**From:** Havis, Sean [REDACTED]  
**Sent:** 22 October 2021 14:50  
**To:** Simon Davis  
**Cc:** Sparkes, Jessica  
**Subject:** RE: \*EXTERNAL: Drove Lane Sales Cabin refs Y/141/21/PL and Y/142/21/A  
**Attachments:** Q81096 - Ryebank Gate A2 Planning Proof-v4.pdf

Client: Barratt Southern Counties
Site: Ryebank Gate
Job No: Q81095 v4
Date: 24/05/2021
Designer: SM

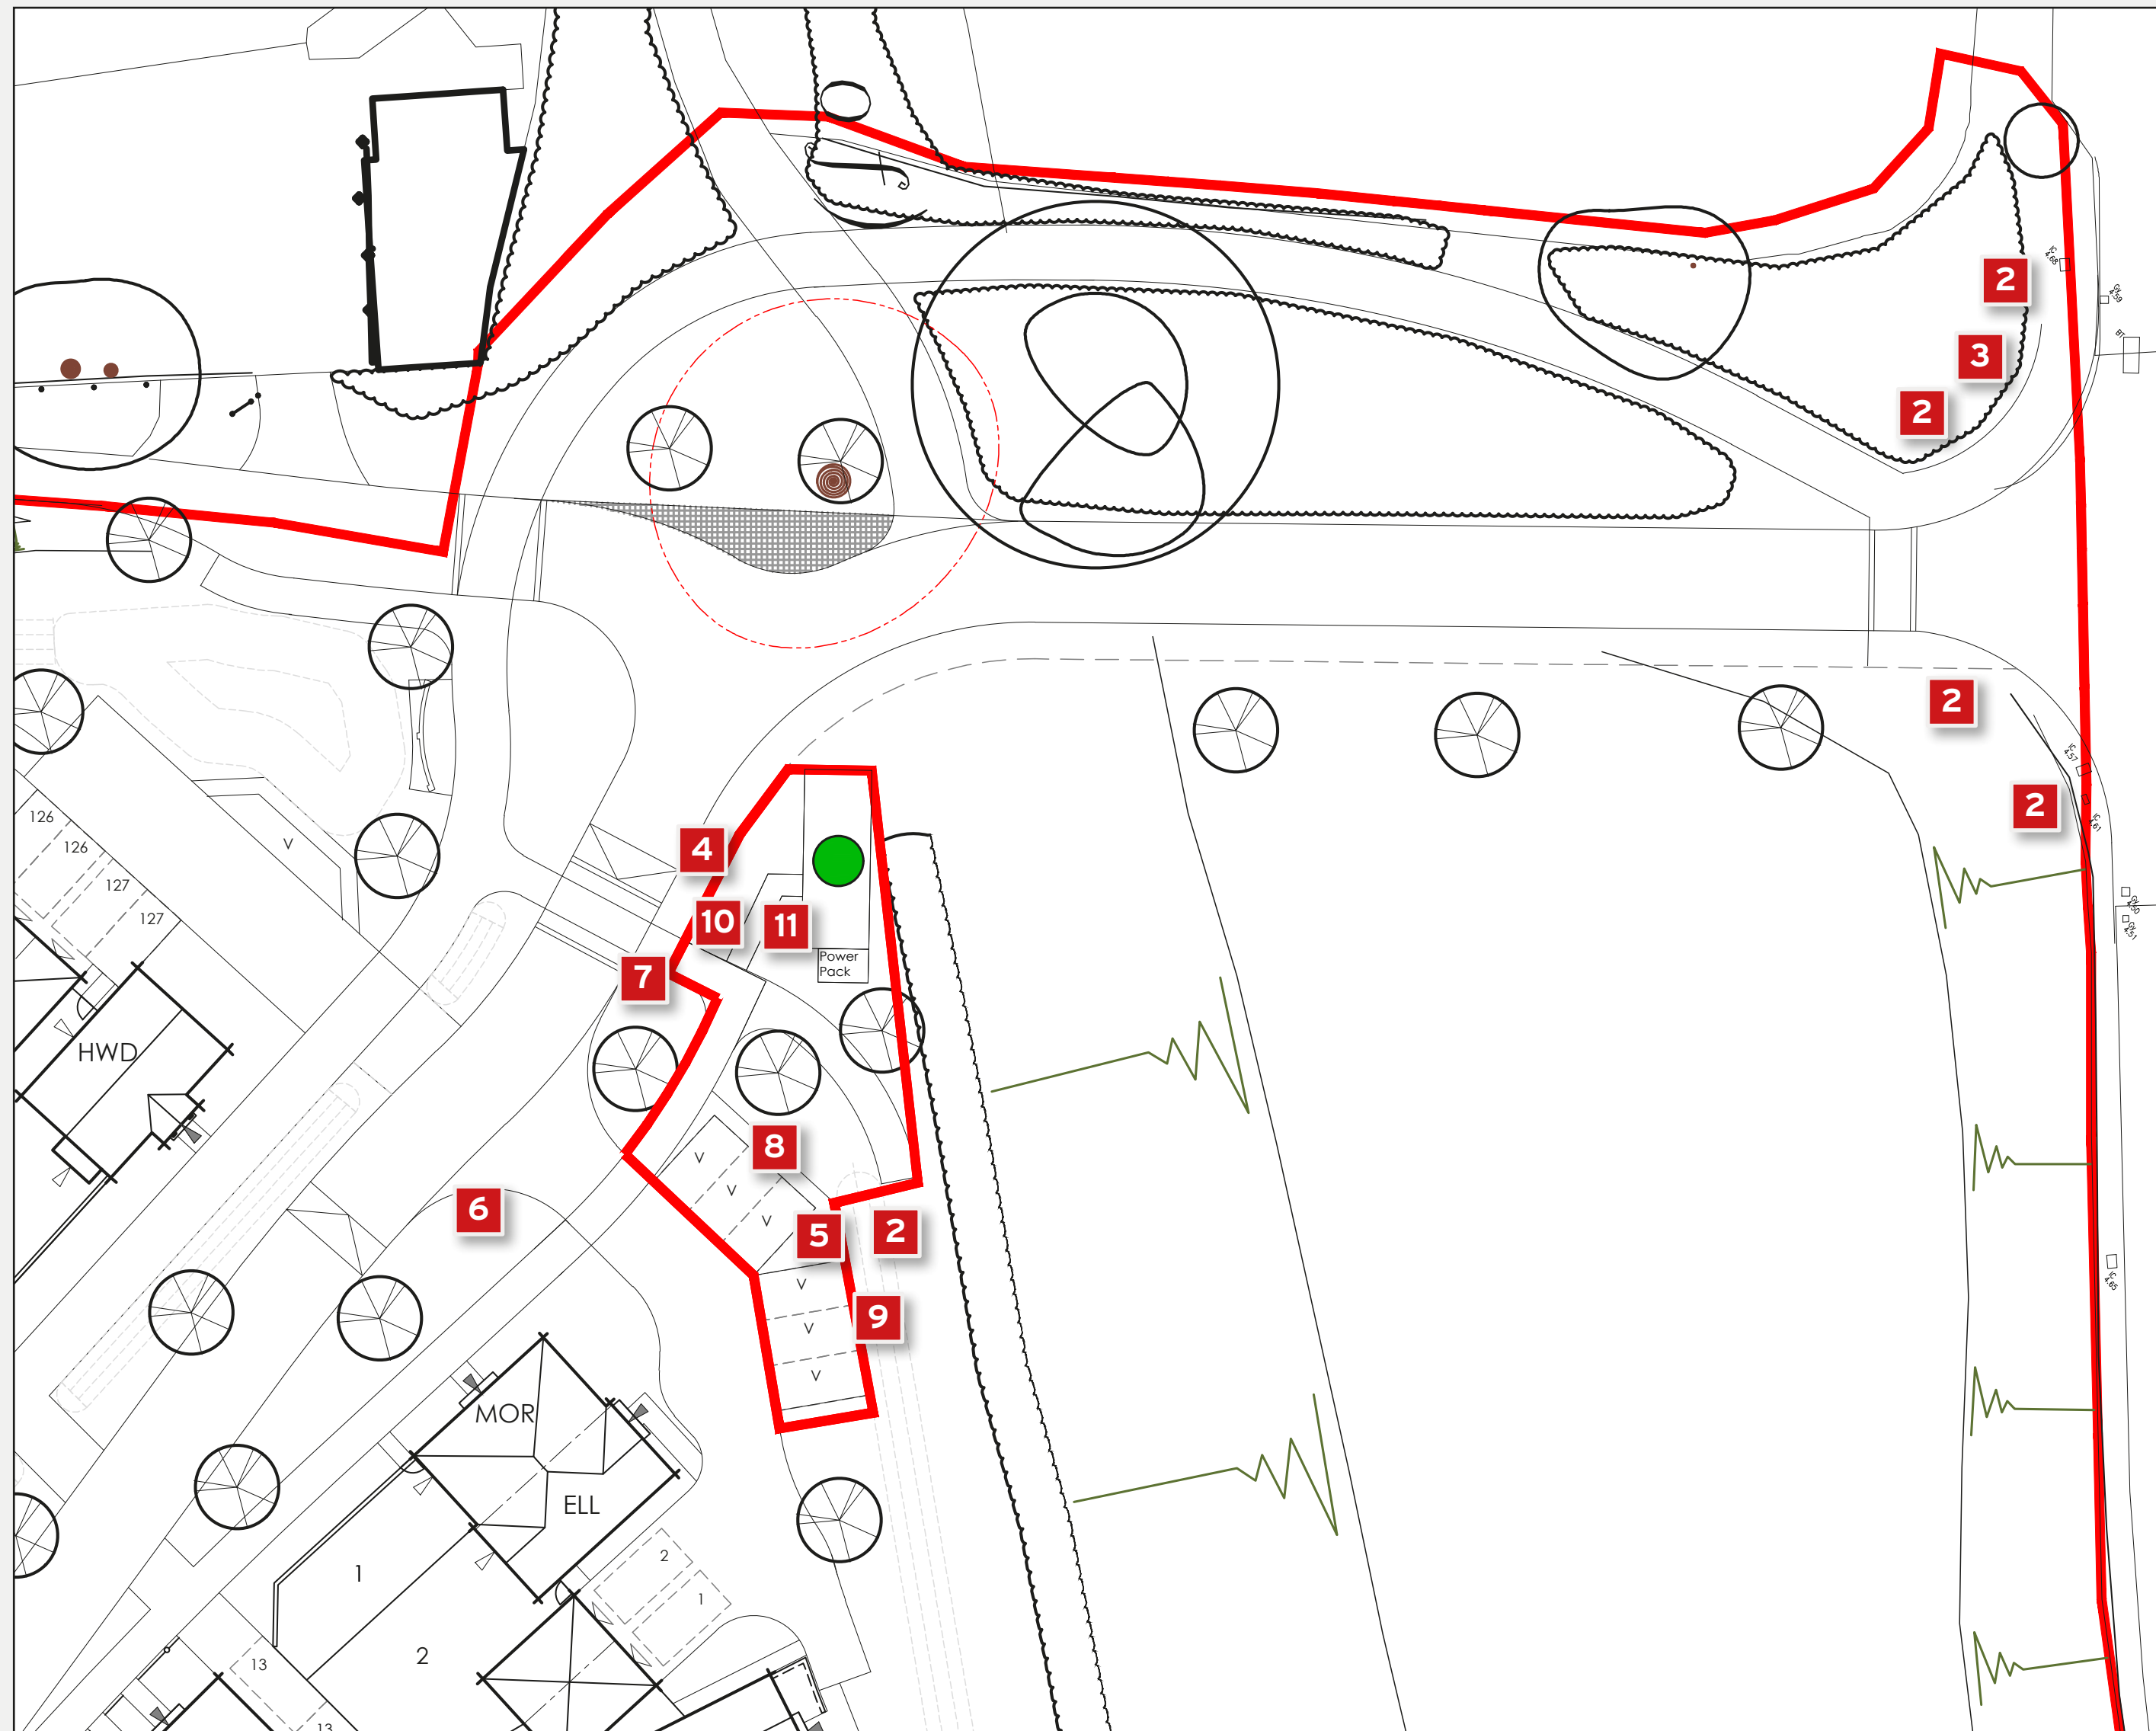
WSCC Highways state that: *"With regards to the proposed advertising the applicant should demonstrate that the totem and static banner flag poles, adjacent to the site access, are located outside of the visibility splay for the main access onto Main Road. If the advertising is located outside of the visibility splay the Highway Authority would not have any objections to the proposals."* Please demonstrate this with a drawing.

WSCC Highways state that: *"With regards to the proposed advertising the applicant should demonstrate that the totem and static banner flag poles, adjacent to the site access, are located outside of the visibility splays for the main access onto Main Road. If the advertising is located outside of the visibility splay the Highway Authority would not have any objections to the proposals."* Please demonstrate this with a drawing. This plan has been requested and will be sent across w/c 25<sup>th</sup> October.

Drawing Title:
SALES AREAS 01

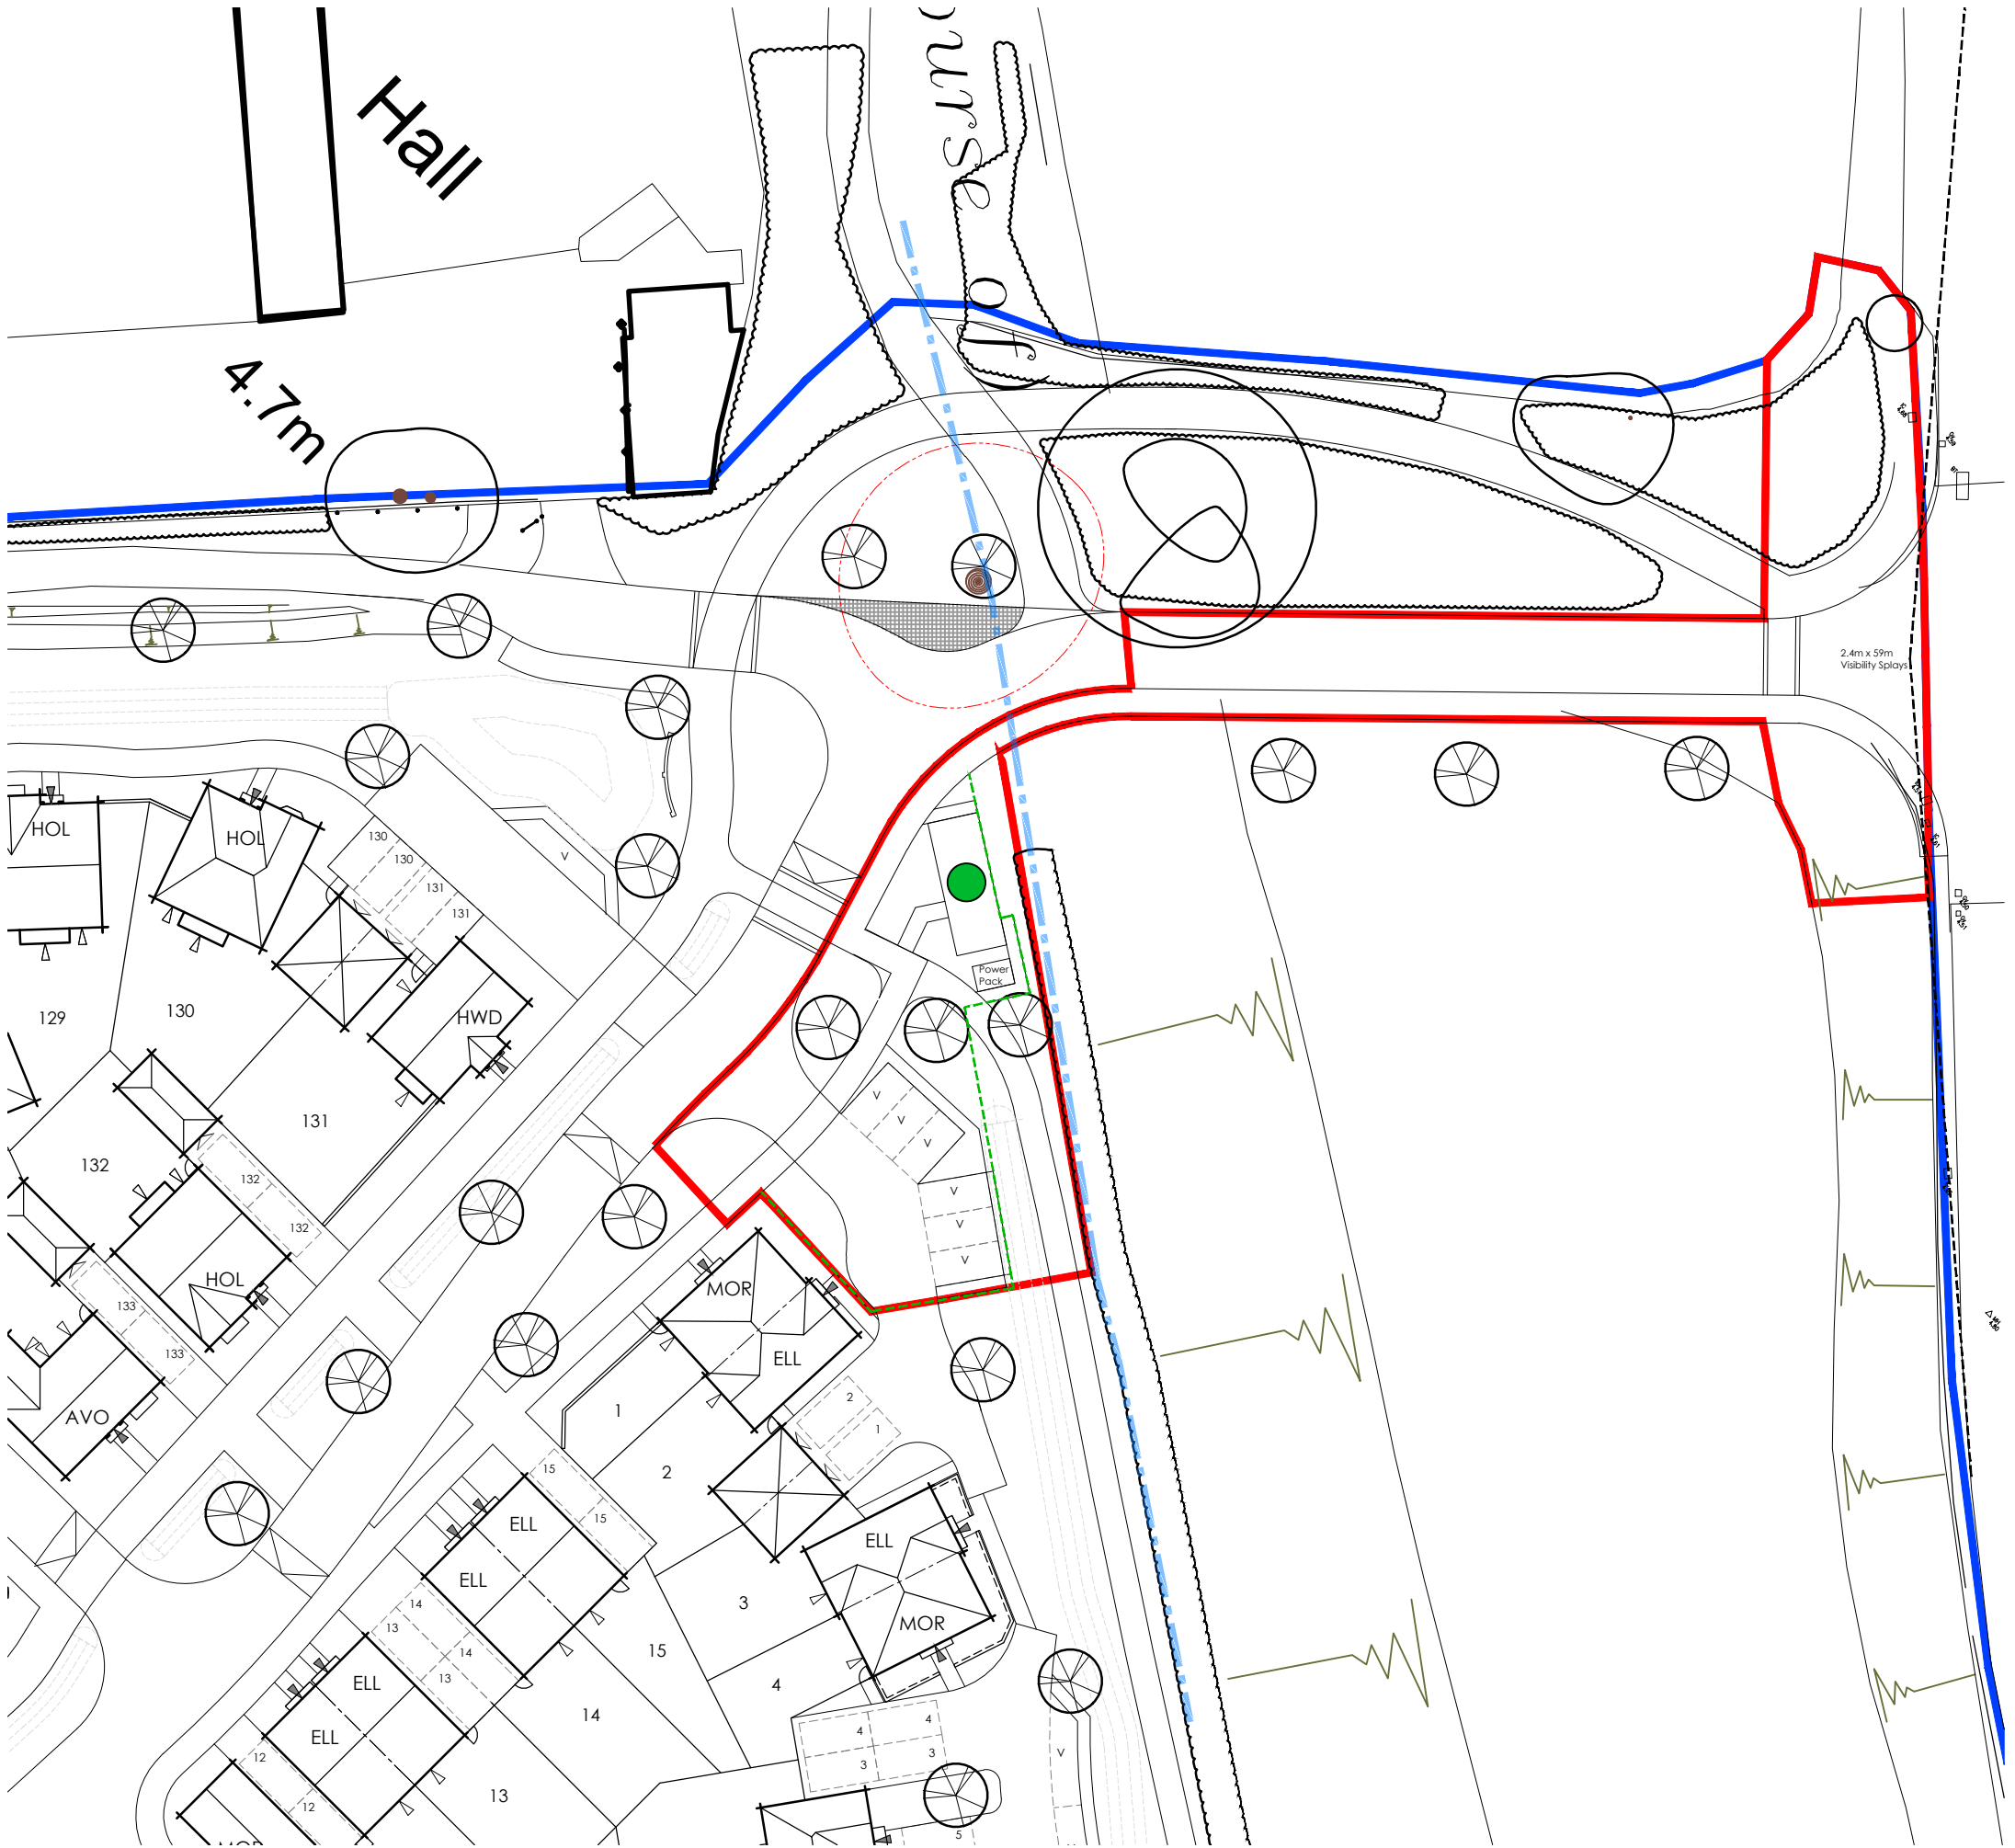
WSCC PRoW state that *"On closer inspection of the Sales Areas (Block Plan) rather than the Location Plan I originally looked at, it is unclear if it is actually sited on FP200\_1. Could you please ask the applicant to show the position of the nearby footpaths on a plan so I can see more clearly?"* Please provide a plan.

WSCC PRoW state that *"On closer inspection of the Sales Areas (Block Plan) rather than the Location Plan I originally looked at, it is unclear if it is actually sited on FP200\_1. Could you please ask the applicant to show the position of the nearby footpaths on a plan so I can see more clearly?"* Please provide a plan. This plan has been requested and will be sent across w/c 25<sup>th</sup> October.
